July 27, 2017

Re: Hagstrom Residence Critical Areas Report, Response to Peer Review Comments

The Watershed Company Reference Number: 160735

SHEET NUMBER:  
W3 OF 7

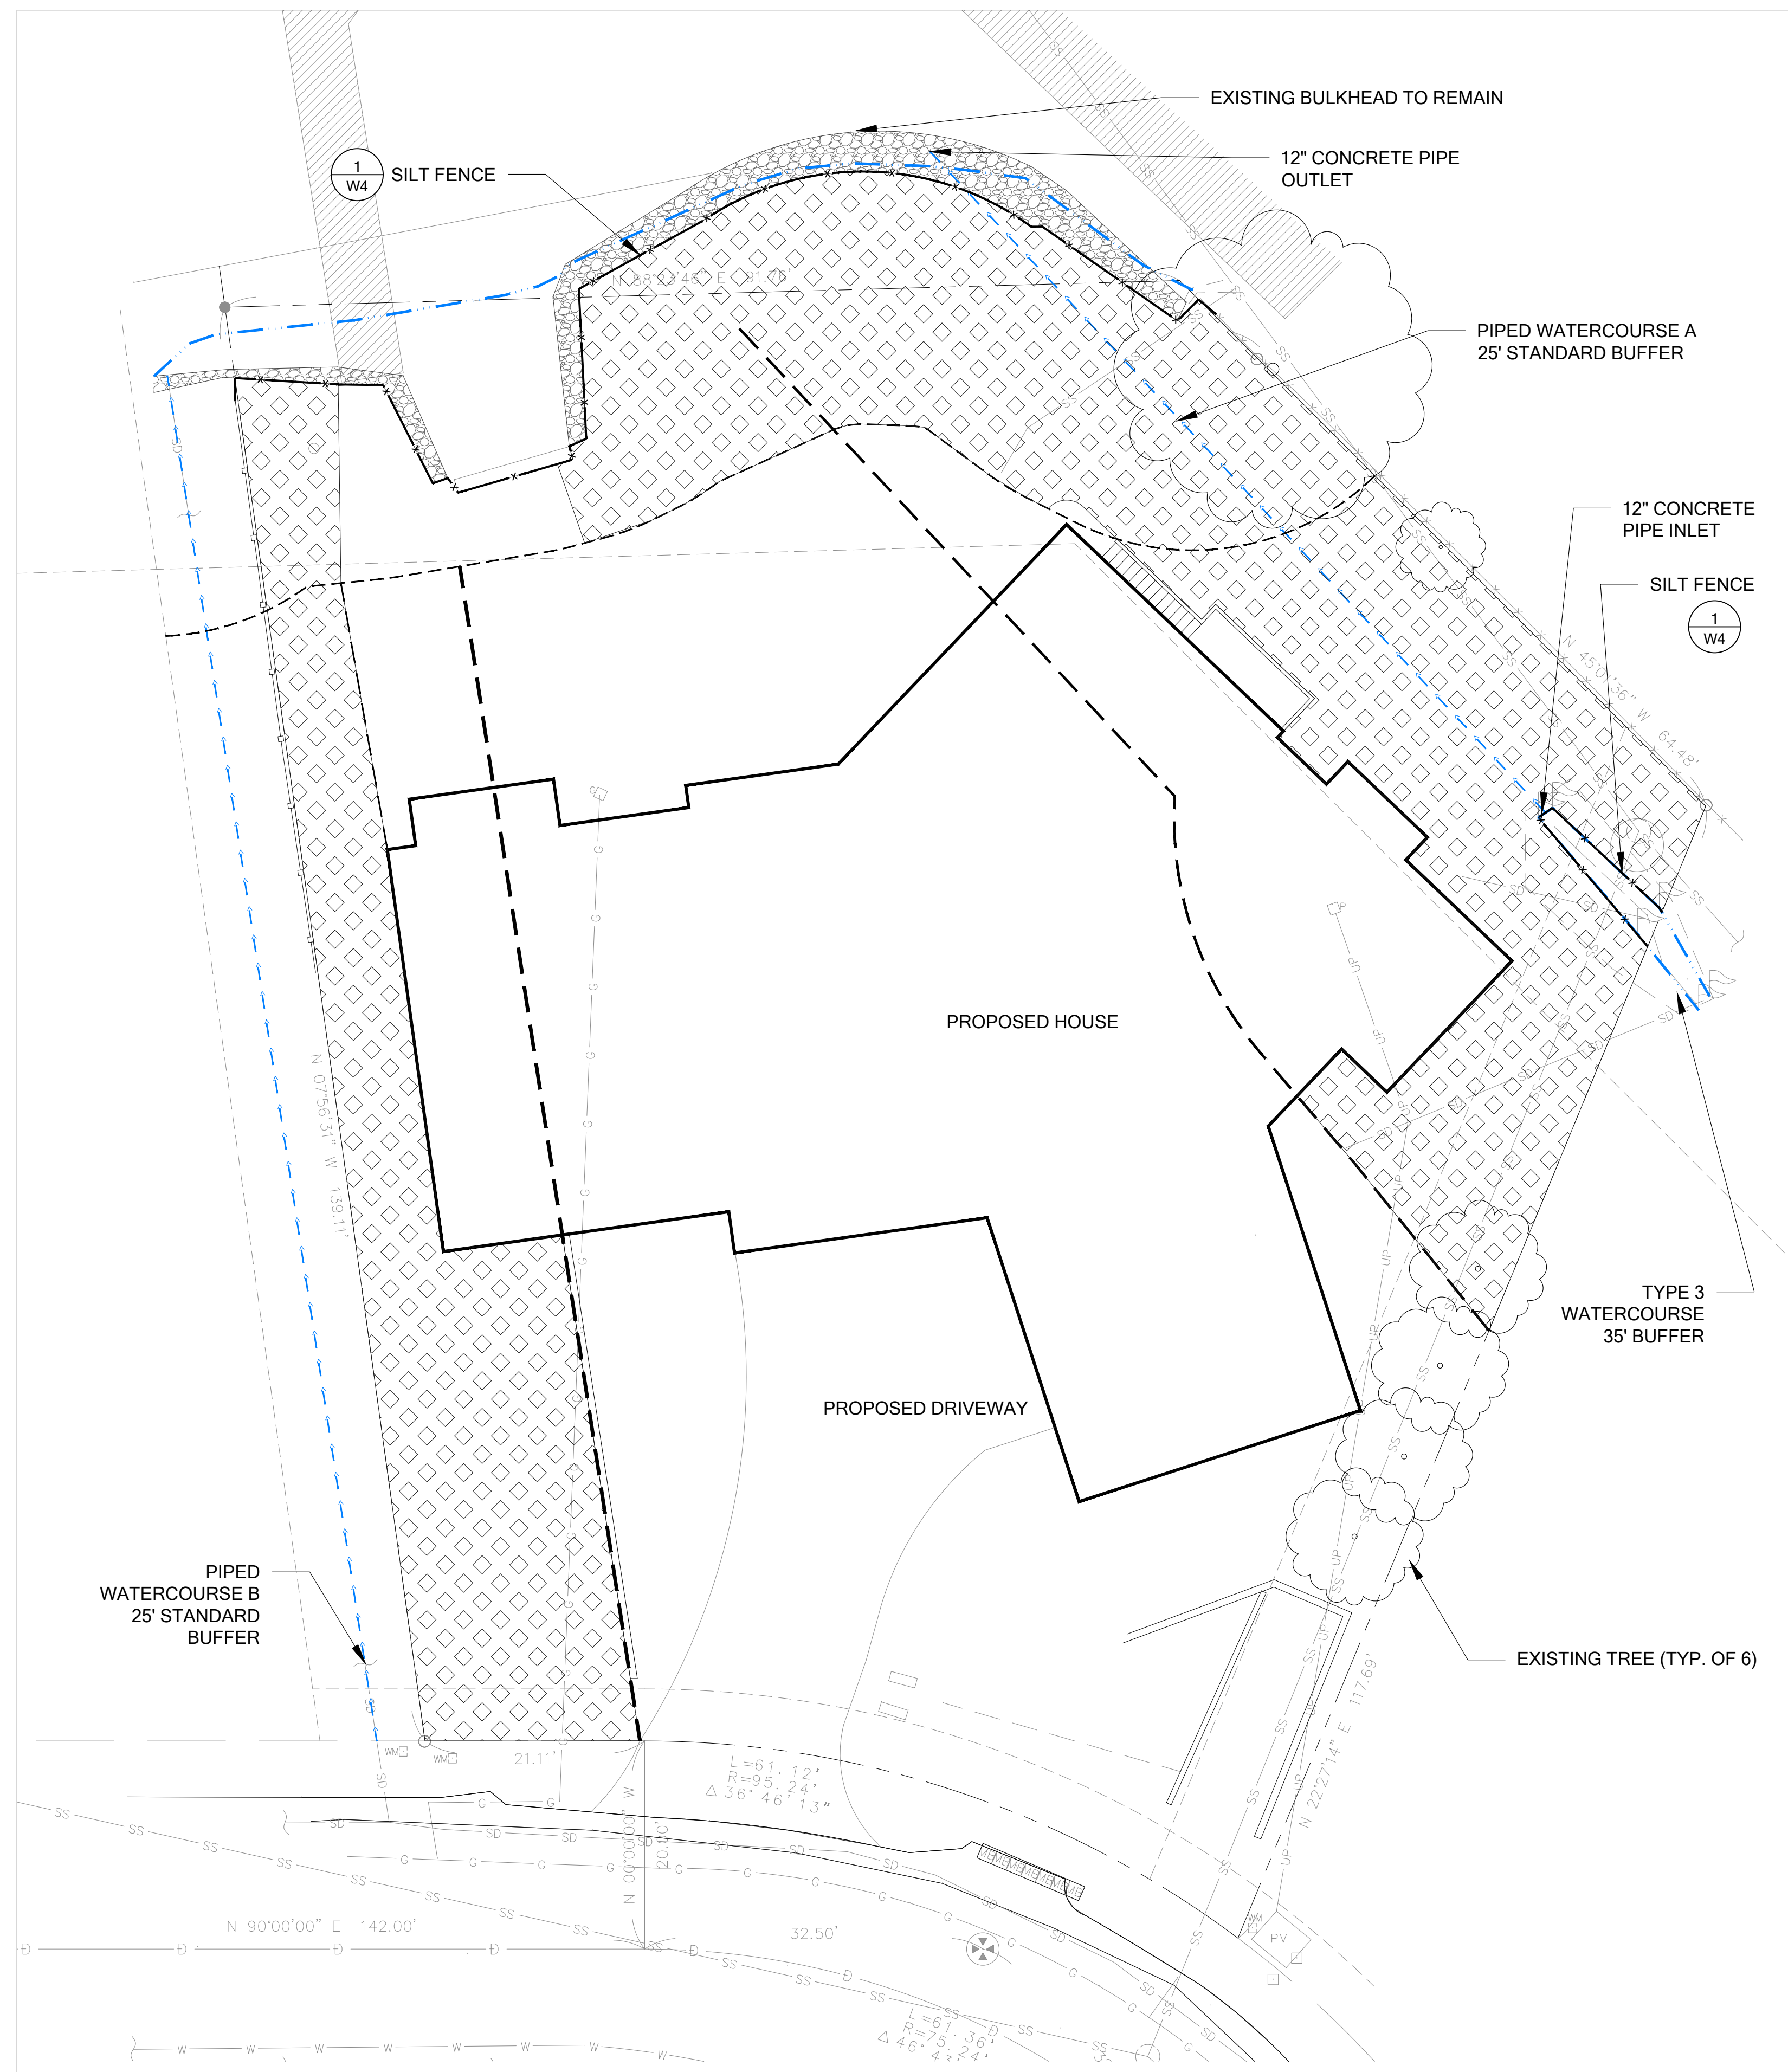
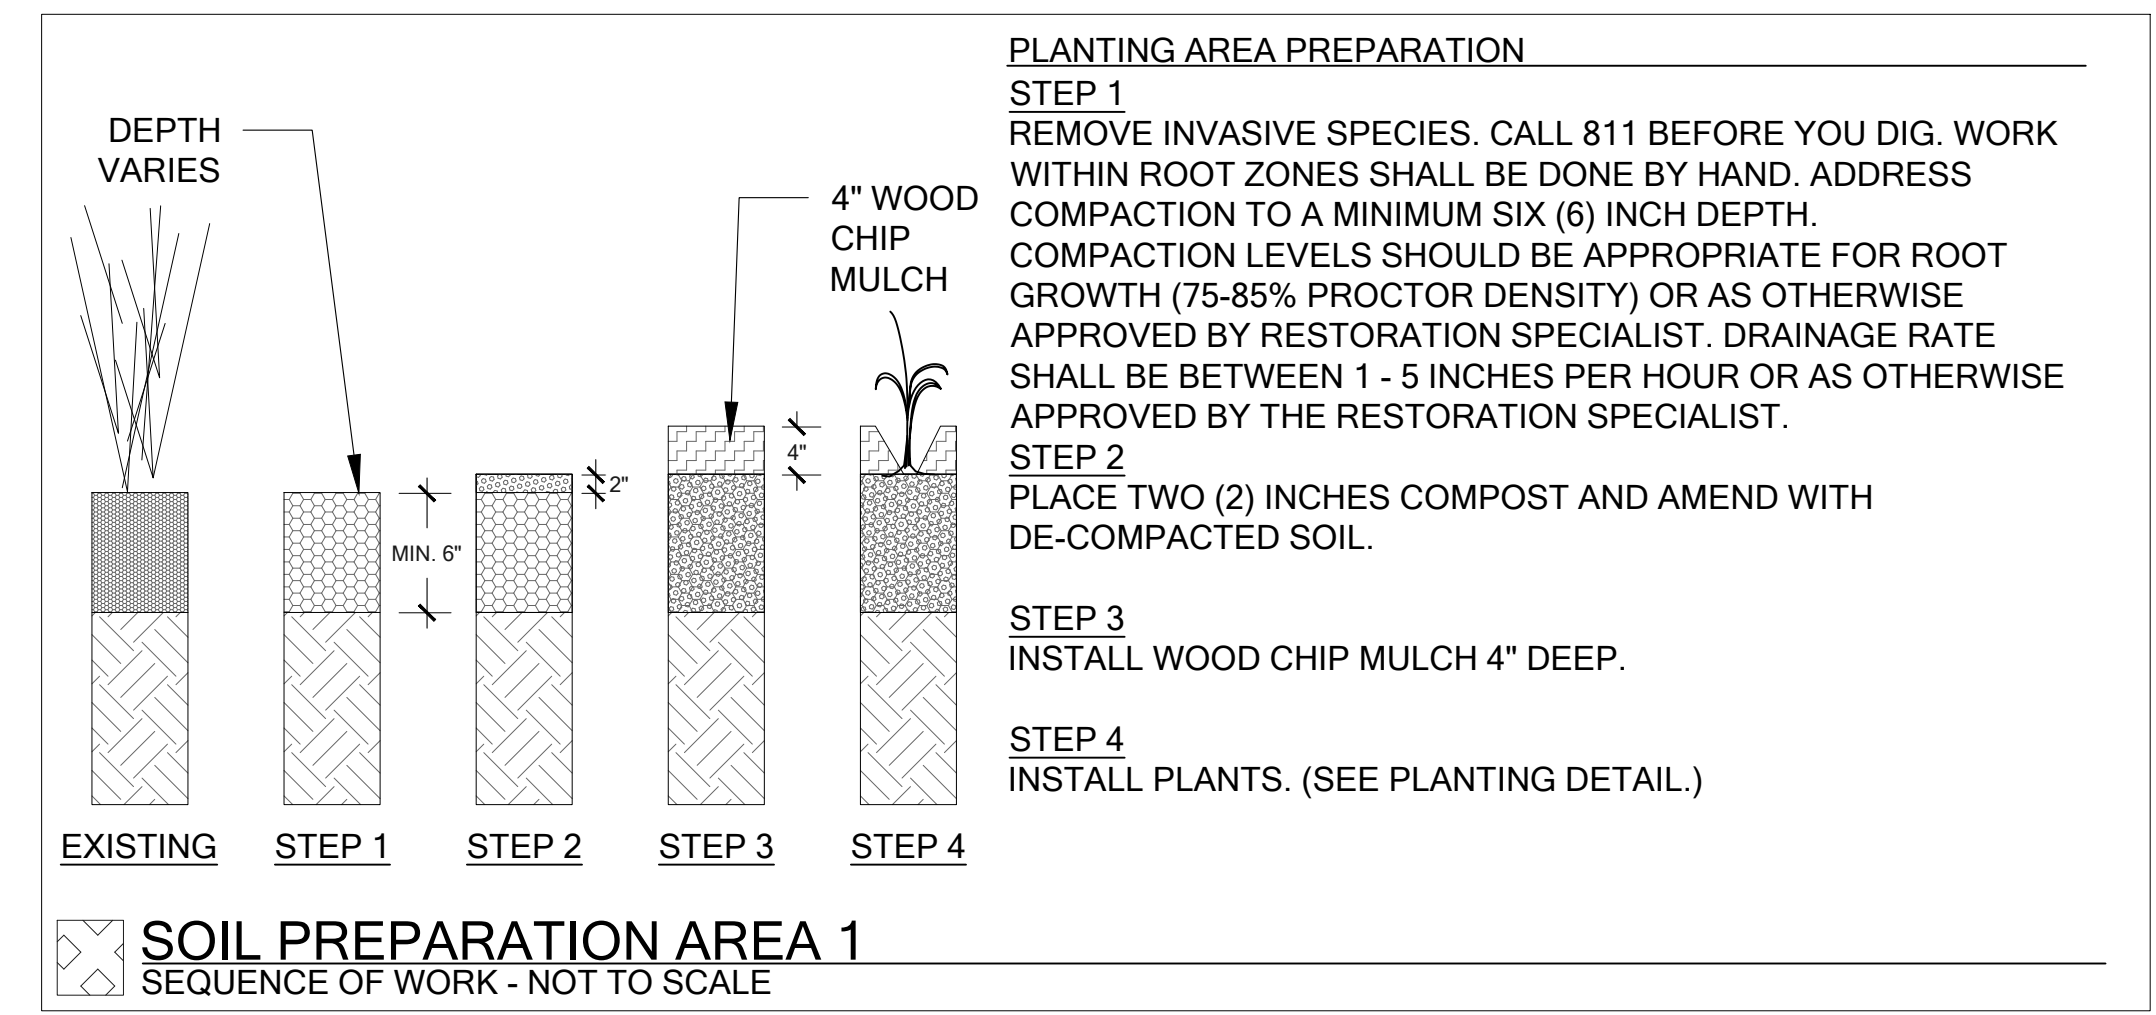
Concern – The study does not specifically delineate minimum buffers which will be maintained for the piped portion of Watercourse A. Specifically, a staircase is shown which appears to encroach within 3 feet of Watercourse A.

Recommendation 3 – It is recommended that the study specifically list and indicate the minimum buffers for the piped portion of Watercourse A. MICC 19.07.070 allows for reduction of buffers around piped watercourses, but stipulates that the reduced area must be adequate to protect the watercourse. ESA's primary recommendation is to consider daylighting Watercourse A (see Recommendation 1). If the applicant provides adequate documentation that portions of Watercourse A cannot be daylighted as part of the proposal, we recommend that the applicant consider opportunities to provide a 5-foot minimum buffer (free from new fill and structures) to the west of Watercourse A in order to preserve ecological buffer functions.. At a minimum, this should include realignment of the stairway on the east side of the proposed structure.

Minimum distances between the proposed improvements and Watercourses A and B have been added to the mitigation plan figures. The minimum buffer widths are shown for the Watercourse B buffer, which is being reduced. The Watercourse A buffer is not technically being reduced; rather, the residence is being reconstructed within the standard buffer under the allowance provided by MICC 19.07.030.A.10 as described above. The standard buffer is still depicted adjacent Watercourse A. The stairs in question have been reconfigured so that they are now located twelve feet from the piped segment of Watercourse A. The closest point any portion of the new development is to Watercourse A (piped or open channel) is nine feet.
